DECISION DELEGATED TO HEAD OF PLANNING

Application No:	H22-0336-25	Applicant:	Mr P Coleman
Proposal:	Single Storey Rear Extension to Form Dining Room & Internal Alterations		
Location:	Oakleigh House 3 Pinfold Lane Weston		
Terminal Date:	15th August 2025

Ground Floor (part)
1 : 50

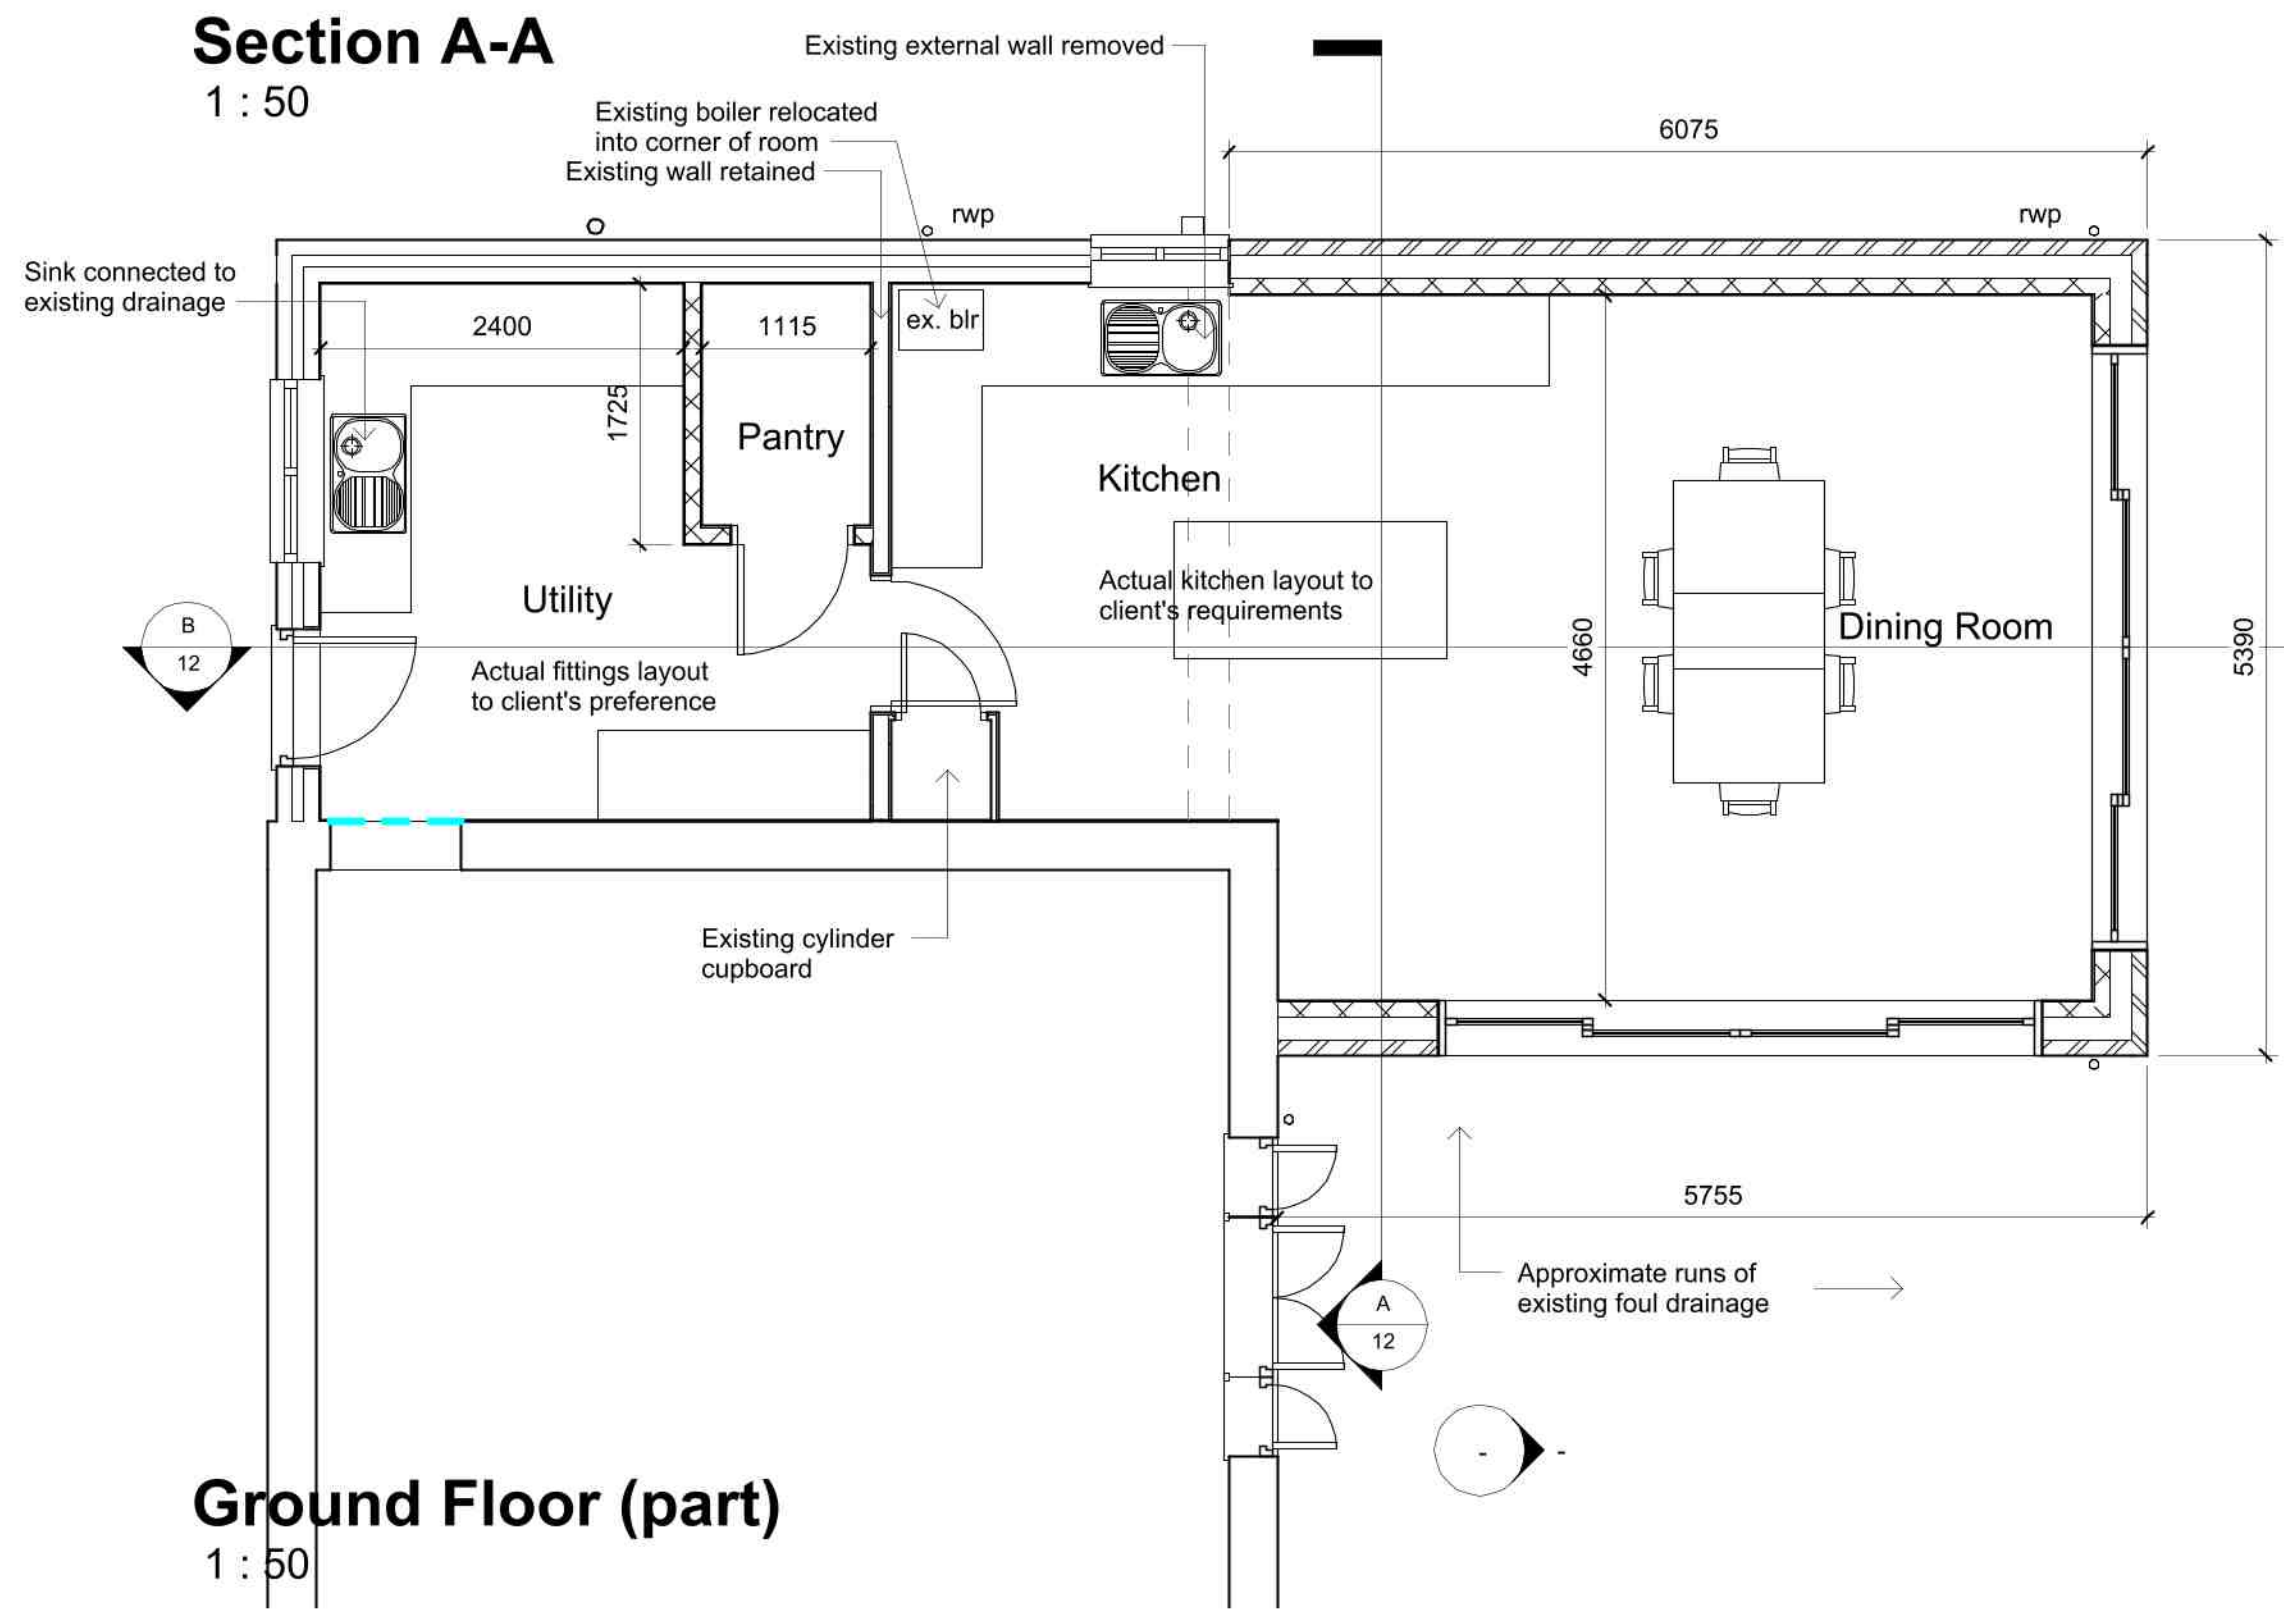
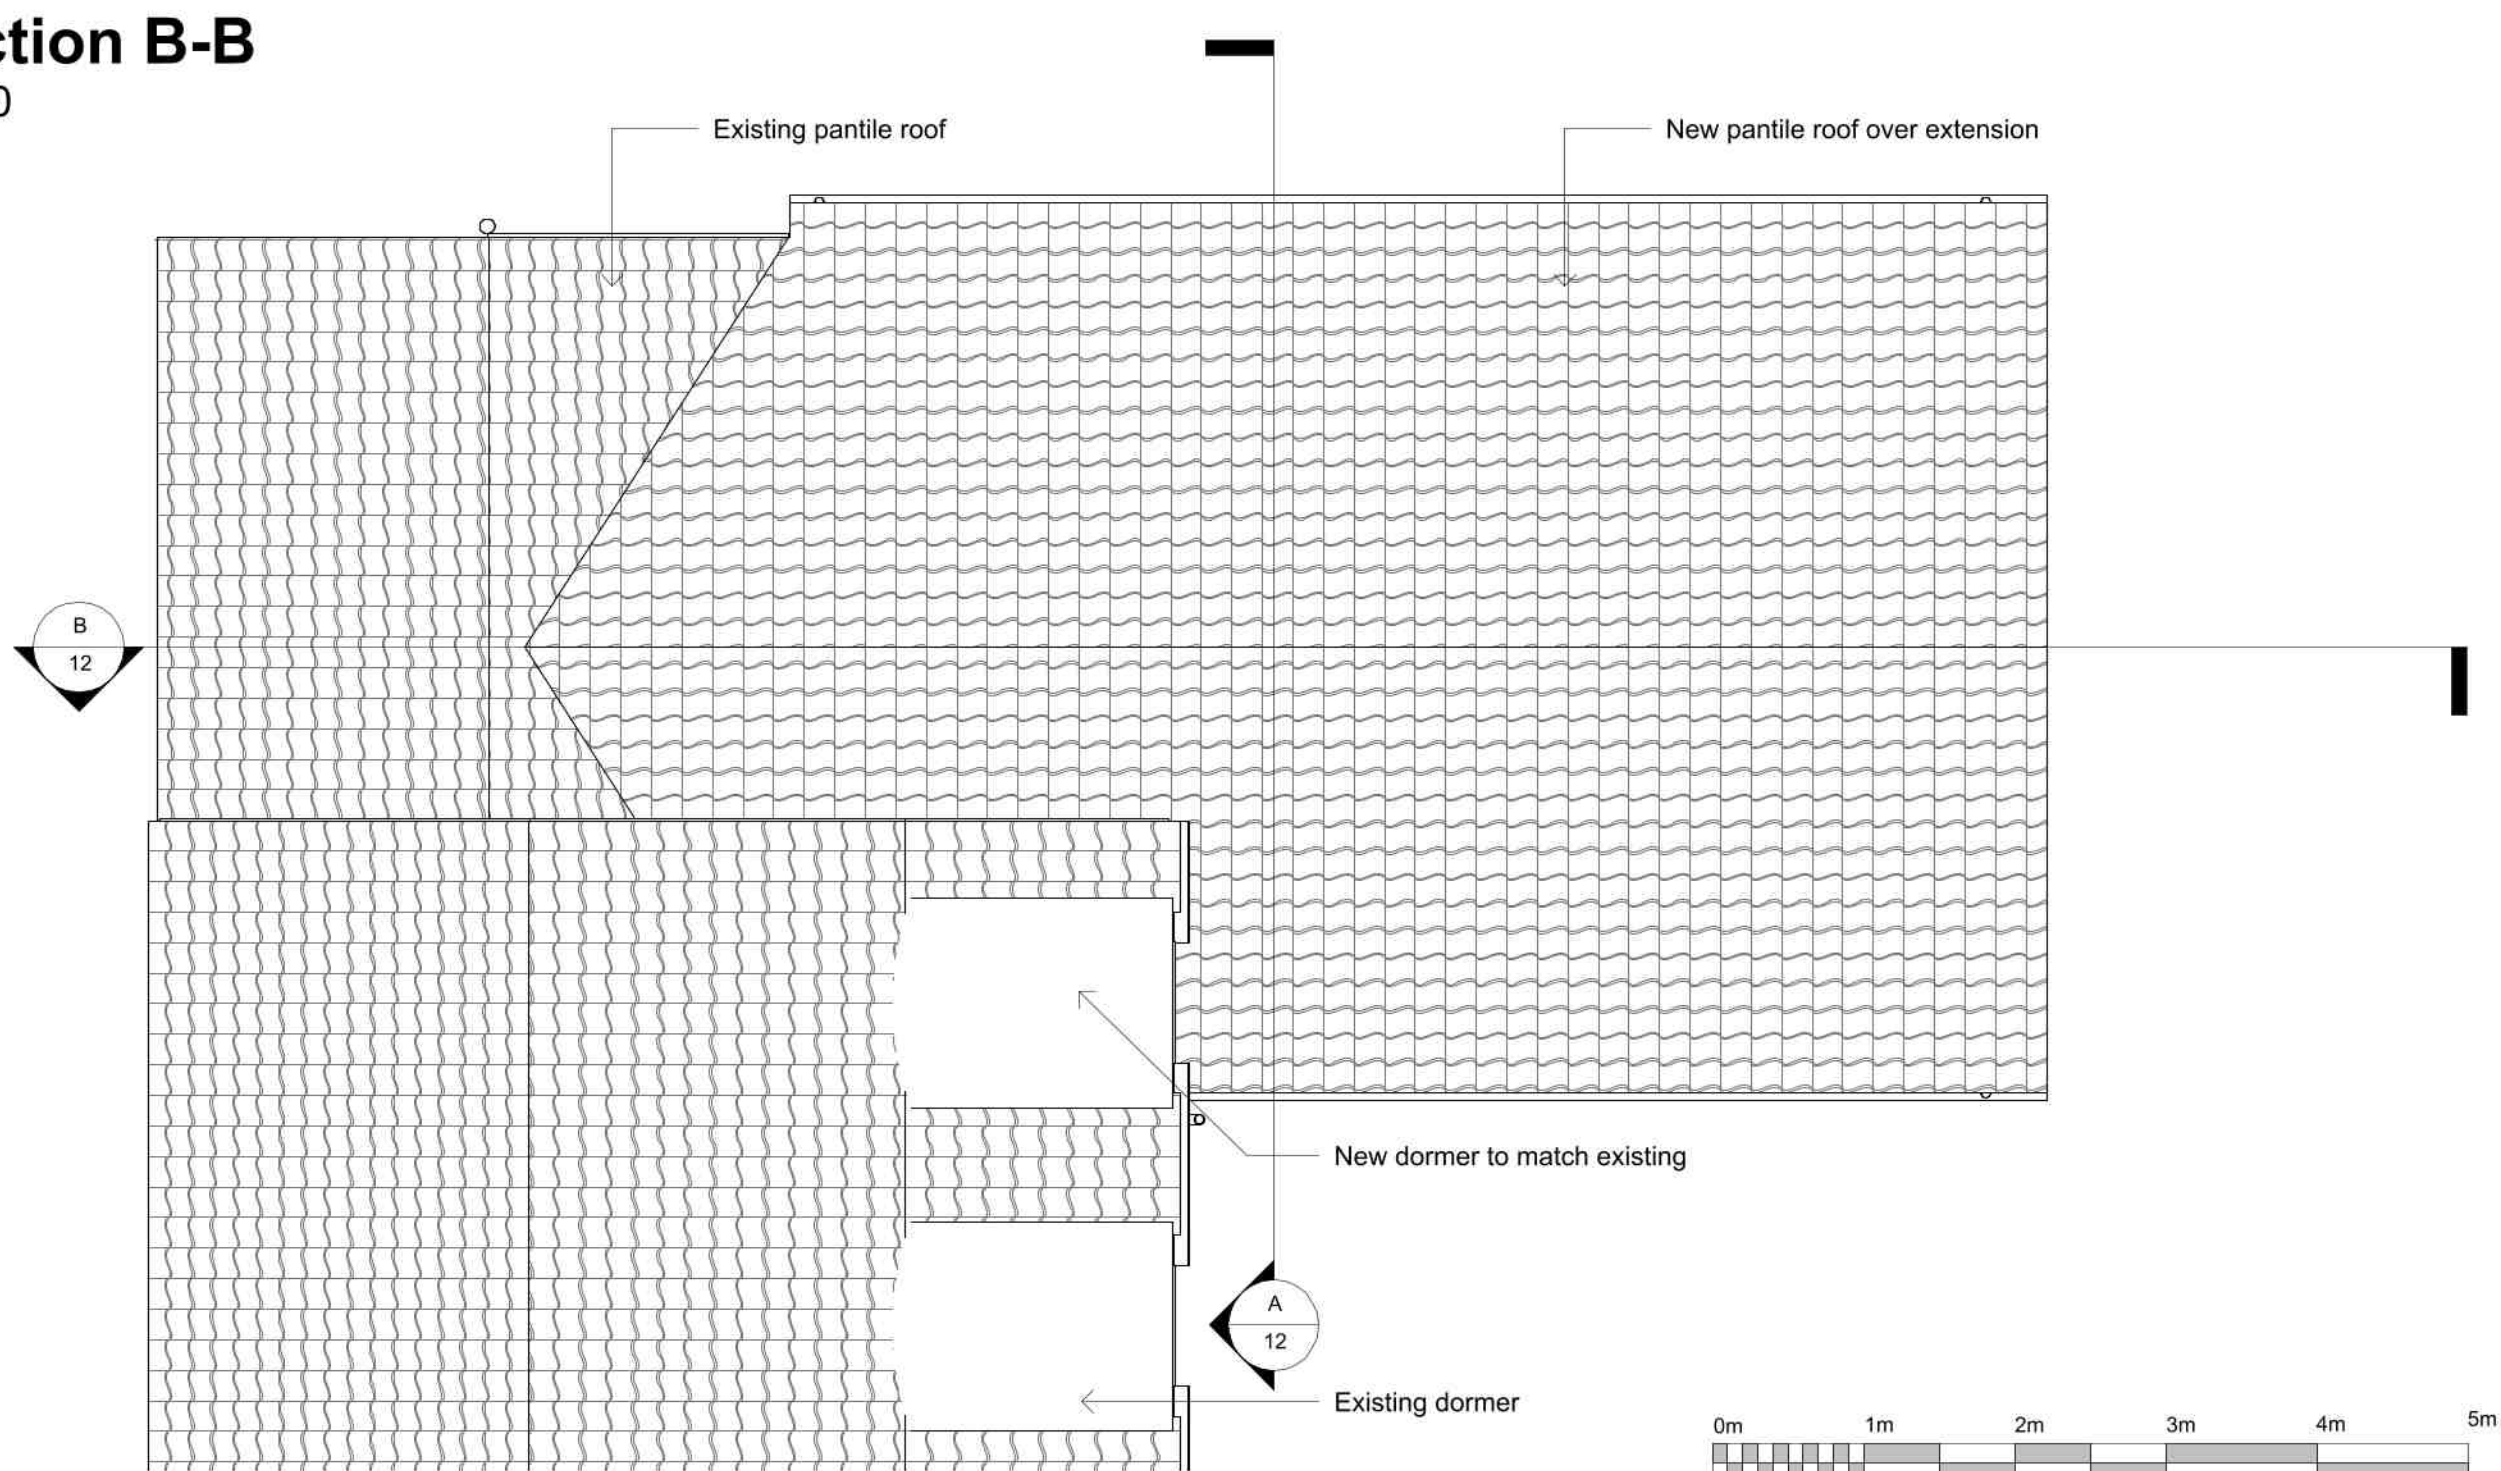
The applicant has provided an amended scheme, and the extension now consists of a single storey dual pitched roof structure with bi-folding doors on two elevations, opening into the garden, with the other elevation blank. Materials are annotated on plan and the structure is to be finished in a matching facing brick and pantile.

I write to confirm the removal of objections to this proposal. The new roof arrangement should give the impression of a more authentic addition to a range of secondary structures to the rear of an original listed property, rather than the originally rather awkwardly-grafted on modern facsimile appearance of the original proposal. Whilst this is by no means the most outstanding example, this is a compromise settlement that is more satisfactory, and should not detract from the character of the important frontage range building by appearing to be an out of keeping addition to this - admittedly lower in the significance hierarchy - later addition of rear range buildings. However, the success of this proposal will be pivotal upon the fine detail and materials of construction. I therefore suggest the imposition of conditions requiring details of all materials of construction, including a brick sample panel and of all proposed fenestration, doors and also of all domestic accoutrements including rainwater goods. The applicant has indicated in their application form that the rainwater goods would be UPVC - this is unacceptable, and all such goods should be black metal at least - however, this can be settled via a condition instead of further amendment.

The applicant seeks to erect a single storey rear/side extension, which would function as an extension to form a kitchen/dining room. The proposal is for a brick built, dual pitched extension. The plans show that on its short side, the southwestern elevation the extension would measure approximately 5.75m and on its longer side approximately 6.7m, the ridge would sit lower than the existing utility room to which it would attach. The proposal would contain sliding doors on both the northeast elevation and south west. The other elevation (northwest) would be facing brick with no punctuation.

Materials are stated on plan to match existing; this includes both roof dressing as well as facing brick.

NPPF Paragraph 208 requires that LPAs should assess the particular significance of any heritage asset that may be affected by a proposal; the location of the extension, to the side rear, as confirmed by the conservation officer, would extend from a less important/significant part of the listed building and therefore this avoids/minimises the conflict between the heritage asset's conservation and the proposed development. It would also be screened from the street somewhat by the existing conservatory. By virtue of the notion that the extension would not overly impact the listed buildings most significant elements (thus not resulting in conflict between the heritage assets conservation and the kitchen extension), that it is screened from the street and that its scale and massing, whilst large is still subservient to the dwelling then the proposal is considered acceptable in this instance.

Therefore, in line with the conservation officers comments the proposal, is considered acceptable subject to control over materials, including opening and rainwater goods which shall be submitted to and agreed in writing with the local planning authority prior to any above ground works.
